Online Comment

Application H23-0864-25
Location Oak Lodge Saltney Gate Saracens Head PE12 8AT
Proposal Proposed New Dwelling including the demolition of existing domestic workshop

Name Whaplode Parish Council
Address 48 Casswell Drive Quadring SPALDING PE11 4QW

Date Submitted 05-10-25
For/Against Comments

Status

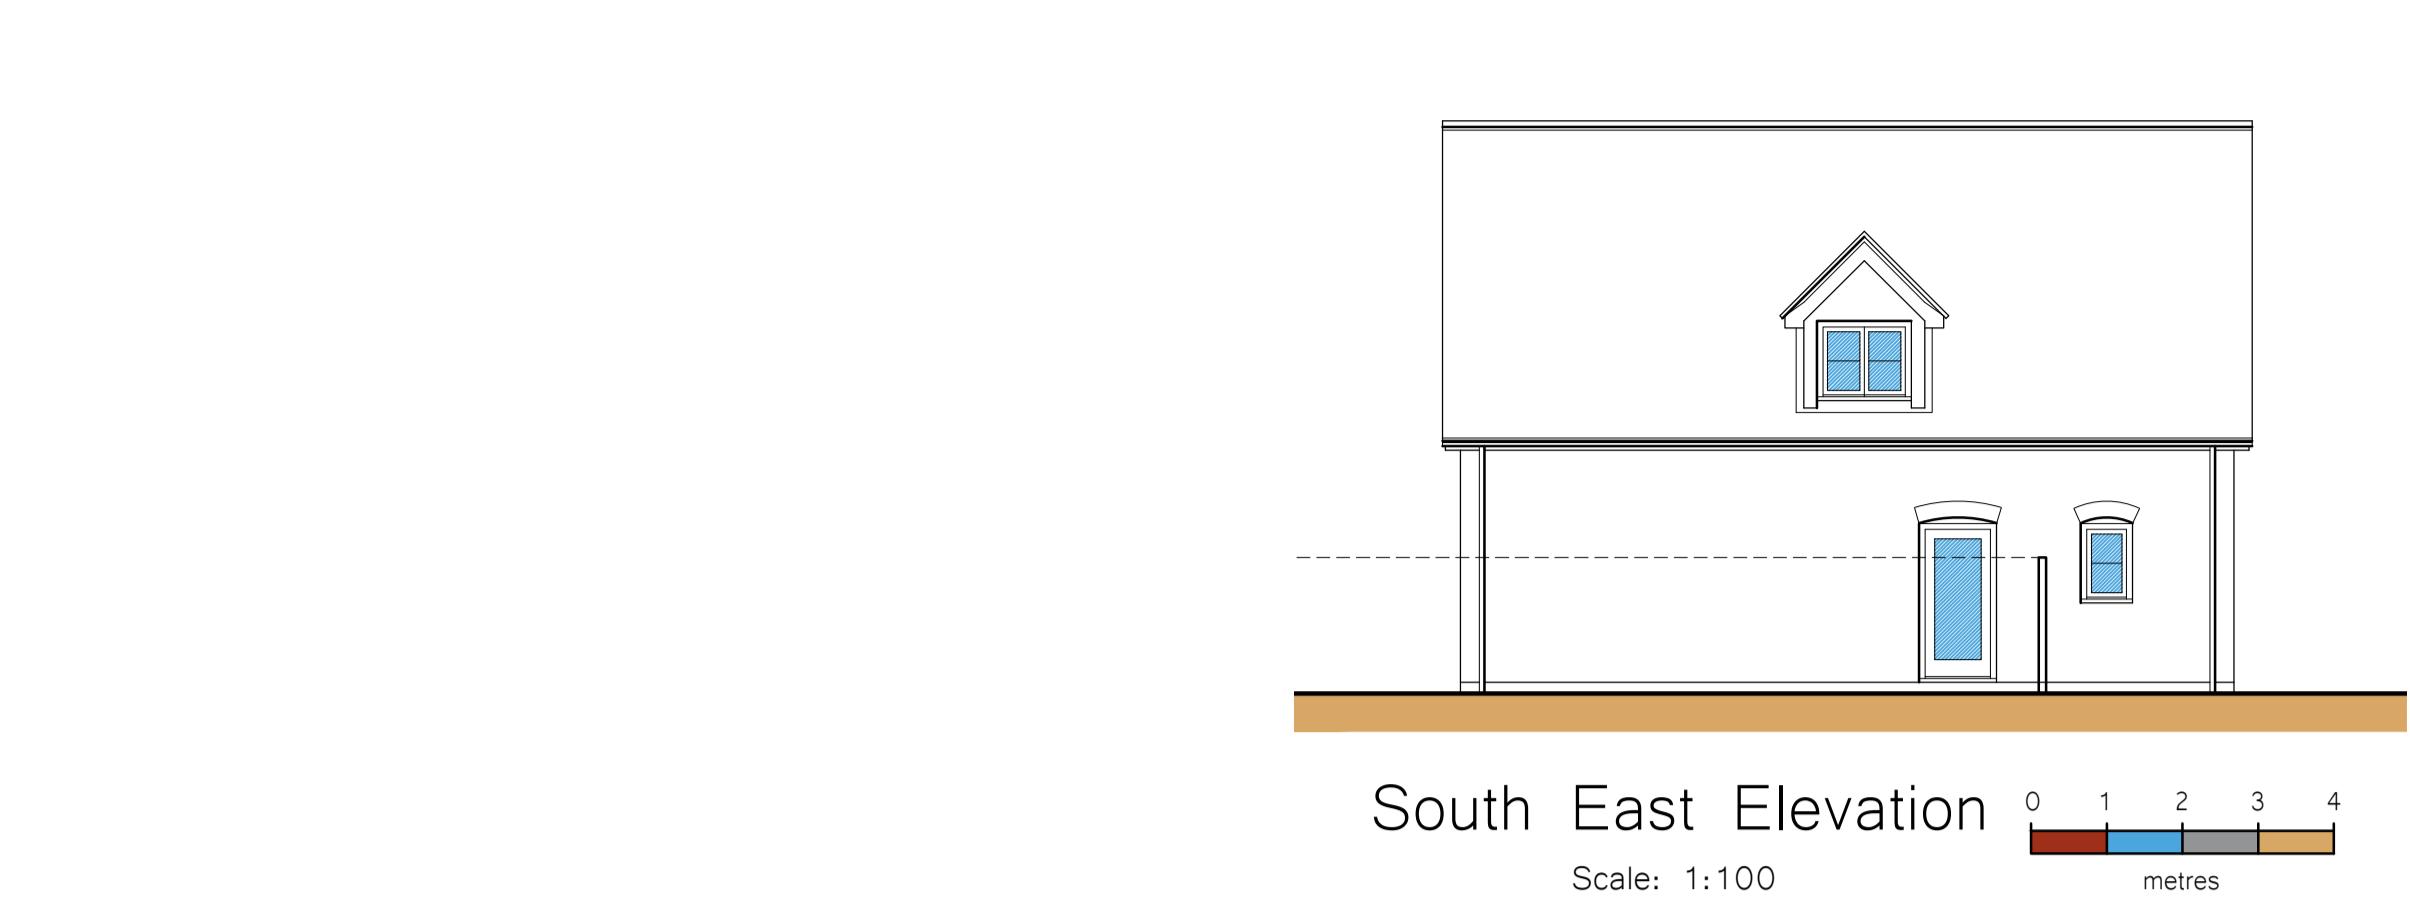
Further to our previous comments, there are other fundamental issues that need to be addressed, contamination, cramped form of development and close proximity to SHIDB piped culvert, does not comply with there bylaws.
